Our ref: NO/2021/113708/02-L02
Your ref: 3/2021/0660
Date: 12 August 2022

PROPOSED WORKS FOR AND USE OF REPLACEMENT SECTION OF AQUEDUCT, INCLUDING EARTHWORKS AND ANCILLARY INFRASTRUCTURE INCLUDING: A NEW VALVE HOUSE BUILDING WITHIN FENCED COMPOUND WITH PERMANENT VEHICULAR ACCESS PROVISION. WITH THE INSTALLATION OF A TUNNEL PORTAL AND AN OPEN CUT CONNECTION AREA WITHIN A TEMPORARY CONSTRUCTION COMPOUND, TO INCLUDE SITE ACCESSES, STORAGE AREAS, PLANT AND MACHINERY, AND DRAINAGE INFRASTRUCTURE AND A TEMPORARY HAUL ROUTE WITH BRIDGE OVER THE RIVER HODDER. IN ADDITION, A TEMPORARY HAUL ROUTE WITH BRIDGE OVER THE RIVER RIBBLE (AS ONE OF TWO OPTIONS FOR VEHICULAR ACCESS TO THE TEMPORARY CONSTRUCTION COMPOUND); A SERIES OF LOCAL HIGHWAY WORKS TOGETHER WITH A TEMPORARY SATELLITE PARK AND RIDE FACILITY AND A VEHICLE MARSHALLING AREA. FROM LAND NEAR THE CONVERGENCE OF THE HORNBY ROAD, THE ROMAN ROAD AND SHOOTERS CLOUGH TO LAND WEST OF NEWTON IN BOWLAND; WITH HIGHWAY WORKS AT VARIOUS LOCATIONS FROM PIMLICO LINK ROAD, CLITHEROE TO HALLGATE HILL, NEWTON IN BOWLAND VIA CHATBURN ROAD, RIBBLE LANE, GRINDLETON ROAD AND SLAIDBURN ROAD; A HAUL ROUTE FROM LAND SOUTH OF WEST BRADFORD BRIDGE TO WEST BRA

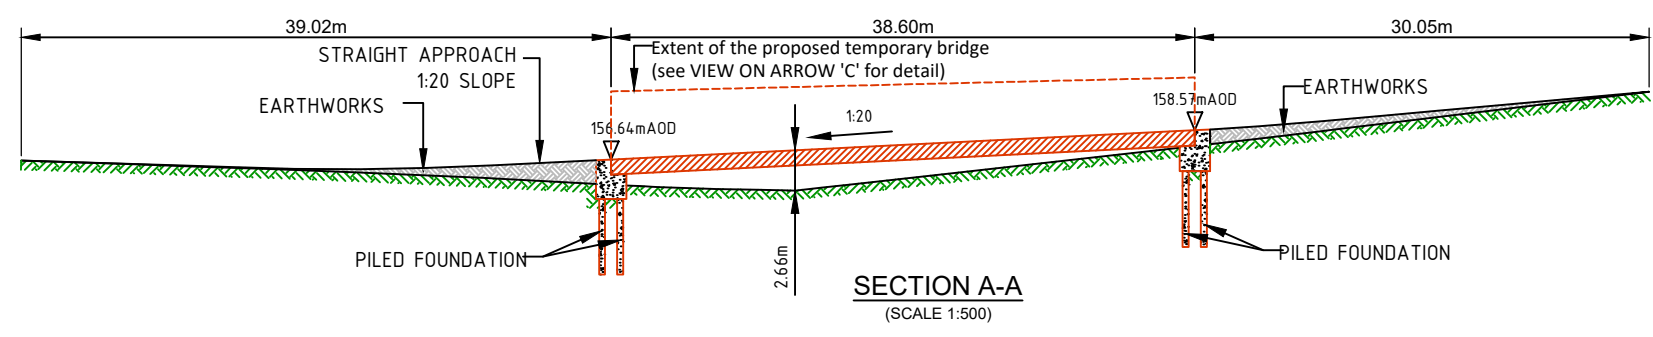
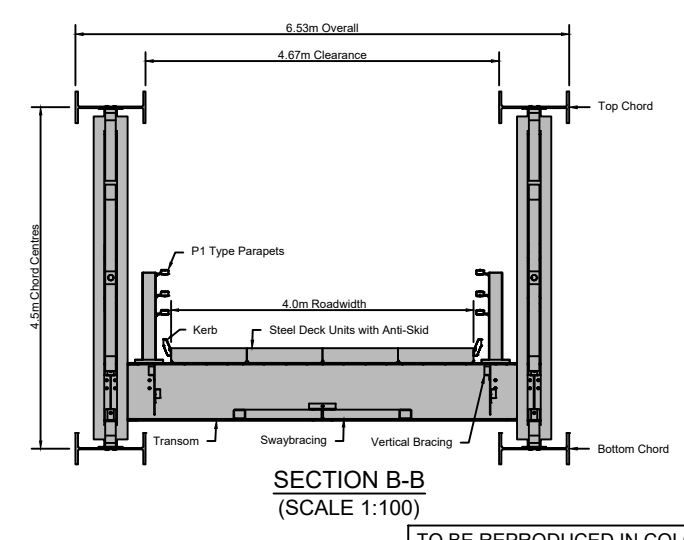
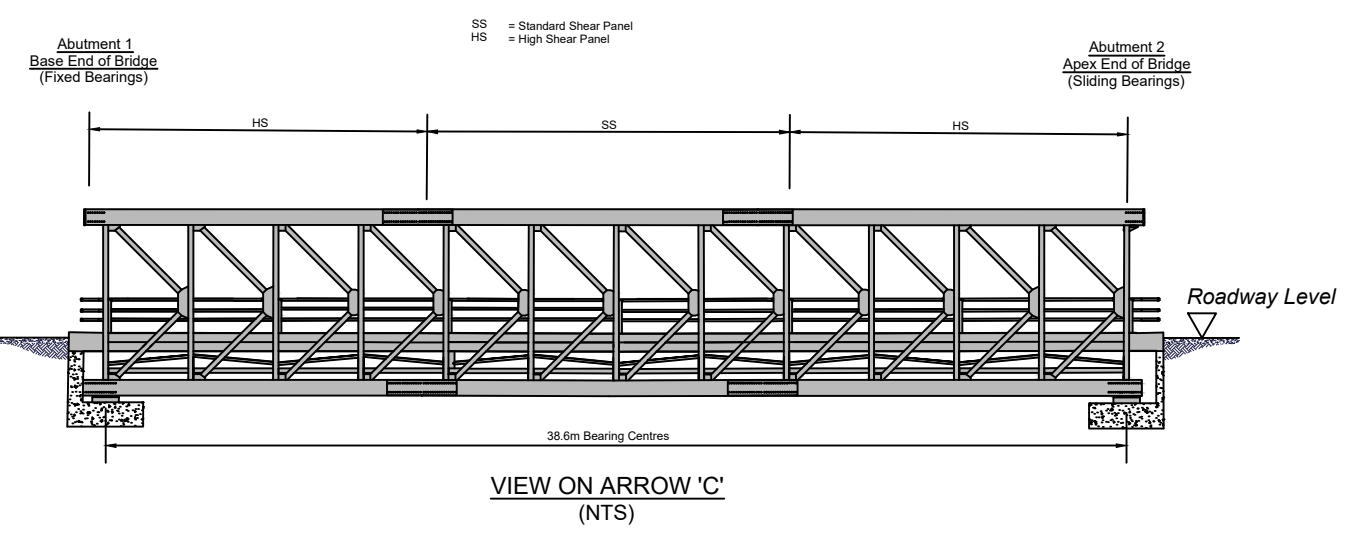
We agree with the conclusion of the GWDTE report which states that the impacts to Gamble Hole Pasture, even with mitigation, are significant, therefore a bespoke compensation package is needed and should be agreed with the local authority. We support the proposed temporary access bridge solution over the Gamble Hole Farm GWDTE site and working in collaboration with Lancashire Wildlife Trust should minimise any adverse effects to this sensitive habitat site.

4. With regards to the Proposed Temporary Gamble Hole Farm Pasture BHS Crossing, we agree that the proposal will substantially reduce the magnitude of impact on the GWDTE. It is noted that a dewatering assessment may need to be carried out for the excavations related to the bridge, and that if dewatering is needed, then an abstraction licence may be required.

SCALE N.T.S.	SHEET SIZE A3
DRAWING NUMBER RVBC-BO-APP-004-12_11	REVISION 0

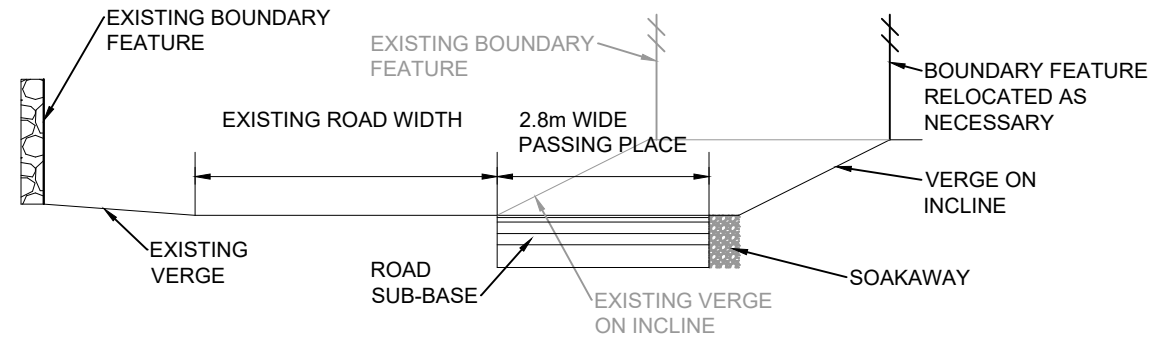
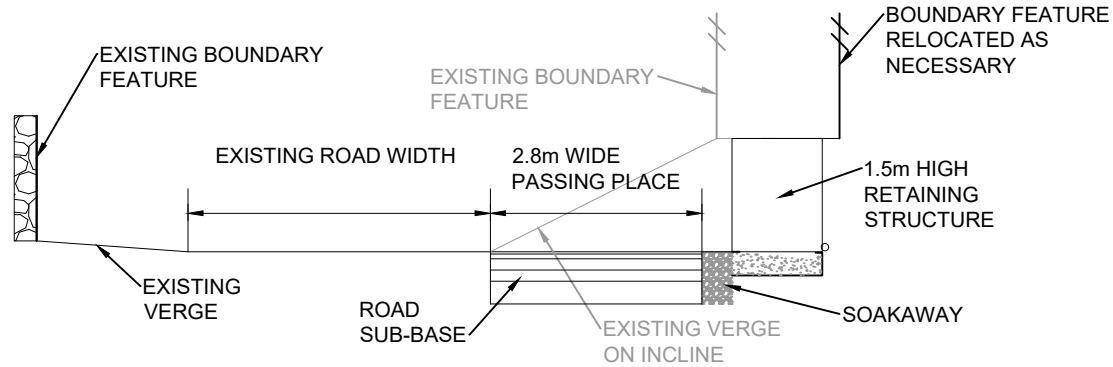
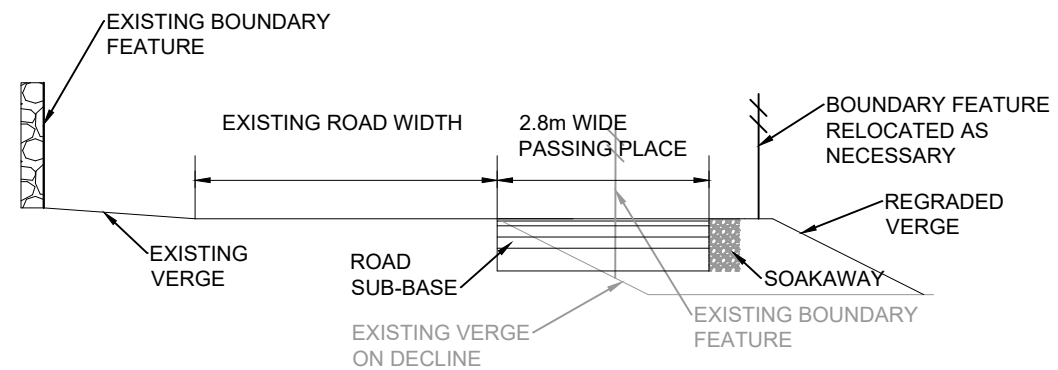
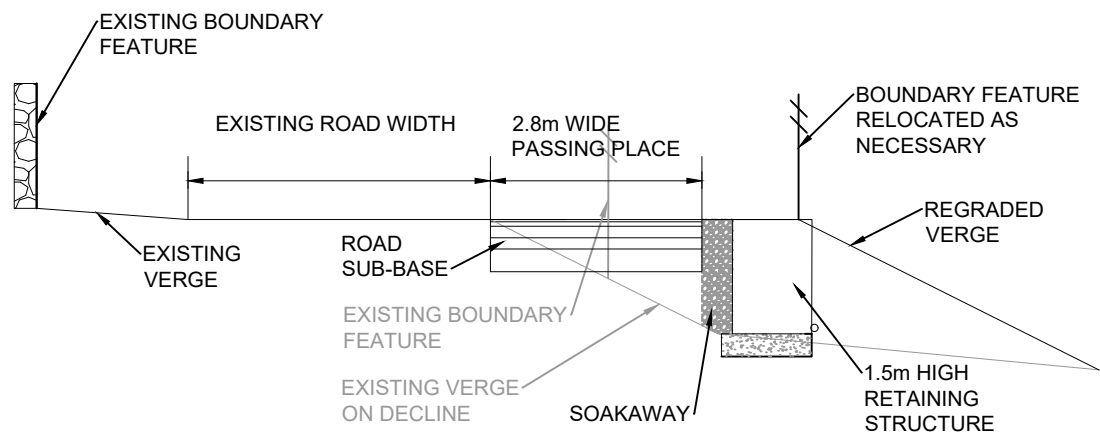
12. The highway access enabling works (widening and passing places) will lead to additional habitat losses not yet quantified in this assessment, therefore no mitigation plans are provided for review at this stage. We recommend that the applicant should provide updated information to capture these additional impacts and ensure the mitigation section is also updated along with the Biodiversity Net Gain assessment. This may affect the area of habitat creation needed off site.

PLAN VIEW
(SCALE 1:1000)

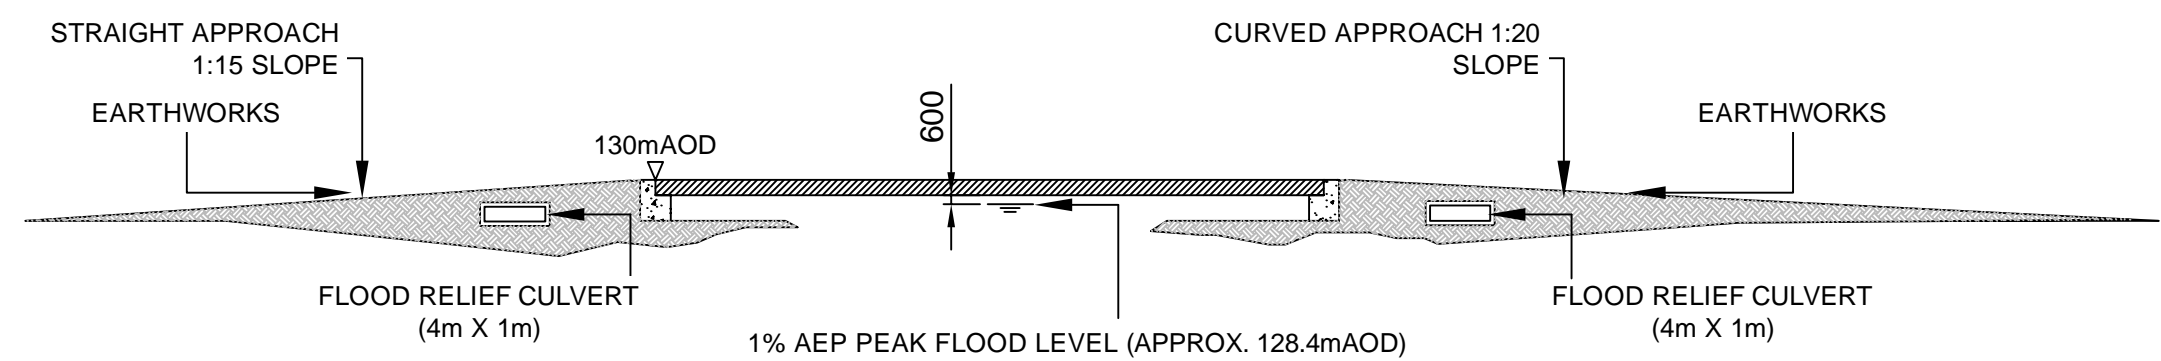
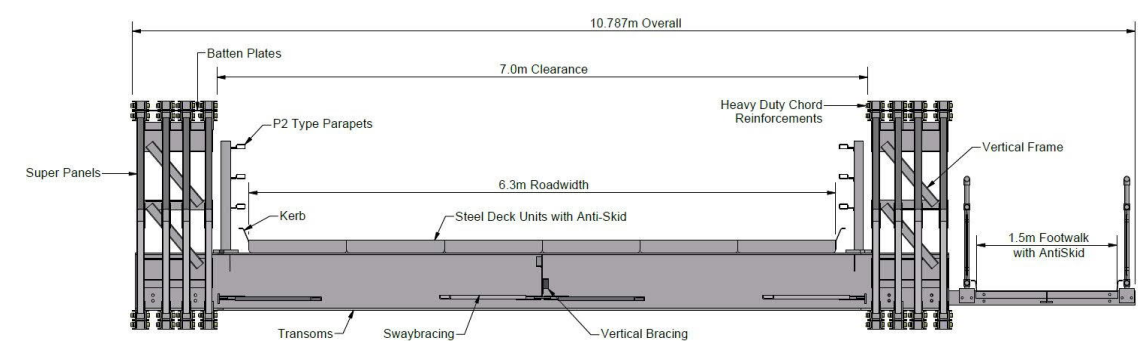
The principle of an open span bridge to carry the haul road across the River Hodder has been established in the submitted plans. These design principles have particular significance as the crossing near Newton-in-Bowland has the potential to cause significant disturbance/damage to bank side and in-channel habitats, affecting fish, otter and geomorphological processes on this section of the River Hodder. The use of an open span bridge is welcomed but the proposed works, which also includes surface water outfalls to the Hodder, still pose a significant risk to the river habitat at this point. This location has high fisheries value providing salmonid and eel migratory routes and habitat for sea trout, brown trout, bullhead and lamprey.

The impact of silt discharge to the River Hodder from proposed surface water runoff from the haul road via outfalls should be considered as locally significant from these proposed works. It is currently unclear exactly how adverse impacts will be prevented/minimised. Currently the application relies on generic mitigation embedded into the wider scheme Construction Code of Practice. Once the detailed designs have been finalised, the applicant will be required to apply for a Flood Risk Activity Permit from the EA and at this stage, the applicant must provide more specific mitigation. The proposed mitigation should address the key risks of habitat damage, disturbance and silt pollution at this location, for example through the use of siltbuster, settlement ponds and treatment of runoff prior to discharge.

The permit application should outline the actual mitigation measures proposed to avoid these adverse effects.
